From: [REDACTED]
Sent: 06 August 2026 16:57
To: Planning
Subject: Comments on the Planning application No: 3/2026/0458. (The old Printworks 4a Back York st . BB7 1LT.)

Please could you record and note the comments as below against the above proposed planning application :-

Proposed Ground Floor
1:100

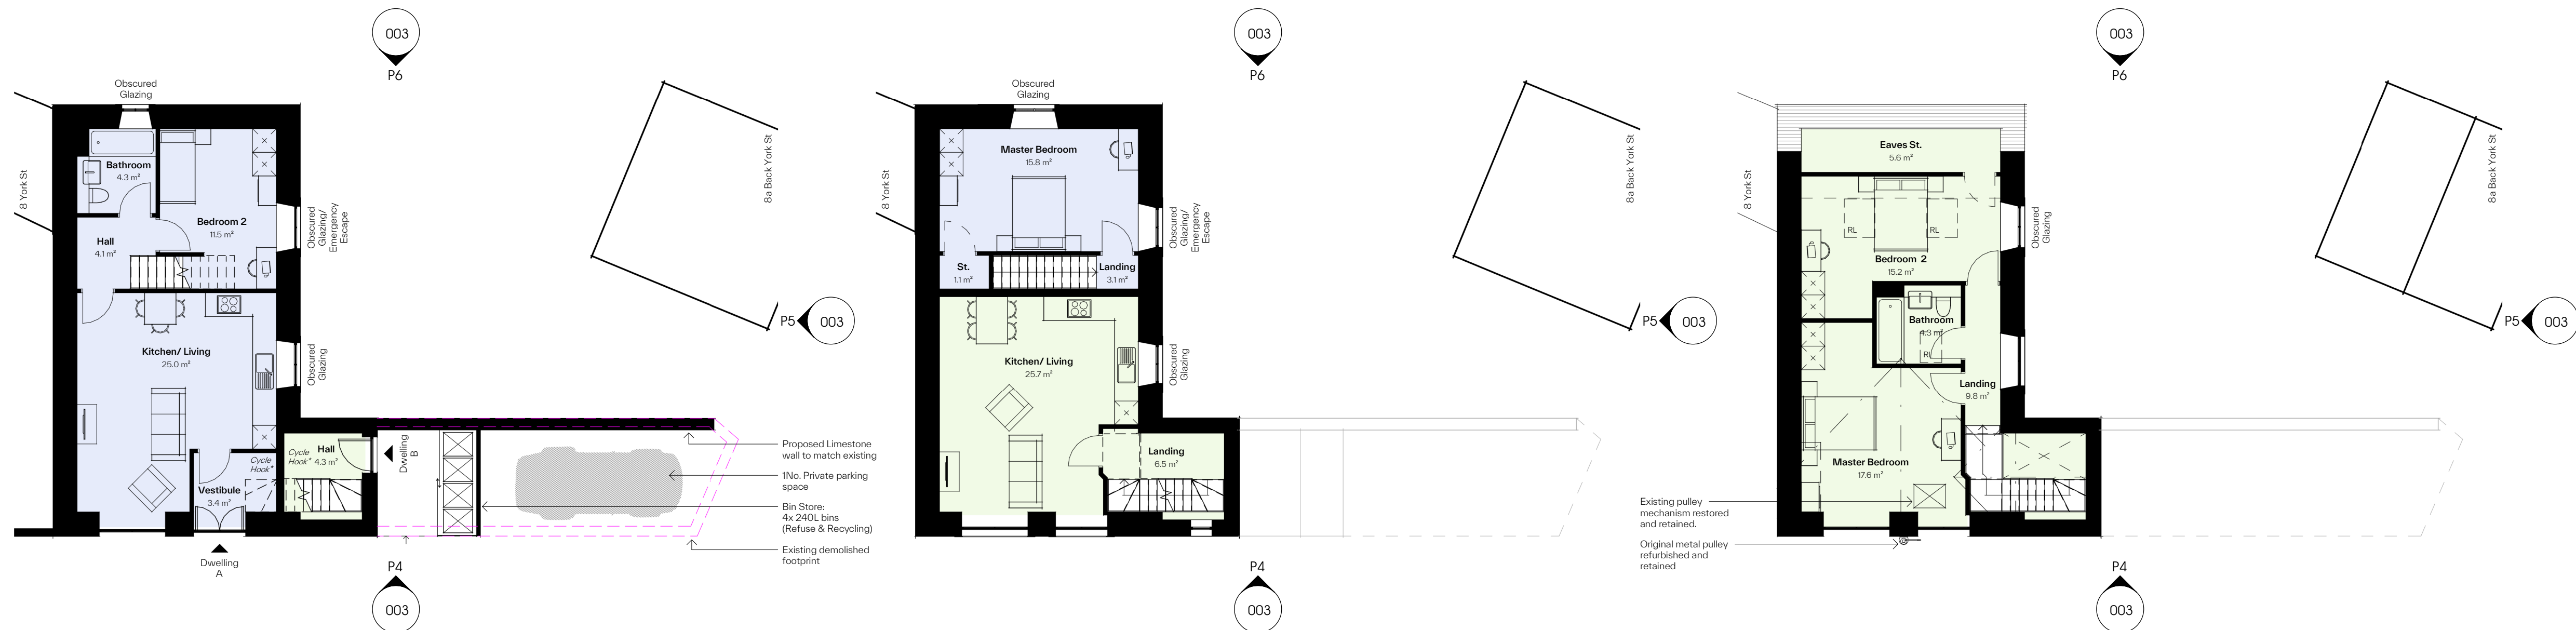
4. We have some concern as to the impact on general access [REDACTED] when the build works are completed. As a Duplex apartments with the provision for only 1 vehicle . Where will other residents presumably with vehicles expect to park their cars ?

As there is a slight widening at the entrance [REDACTED] , I am concerned that delivery vehicles to the proposed property will pull in and potentially hinder and block our entrance.

But if not there is no other passing place either to the front or side elevation of the proposed duplex, other than the single off street space proposed . So we naturally have concerns about Back York street facing future issues caused by the potential residents as well deliver vans etc ?
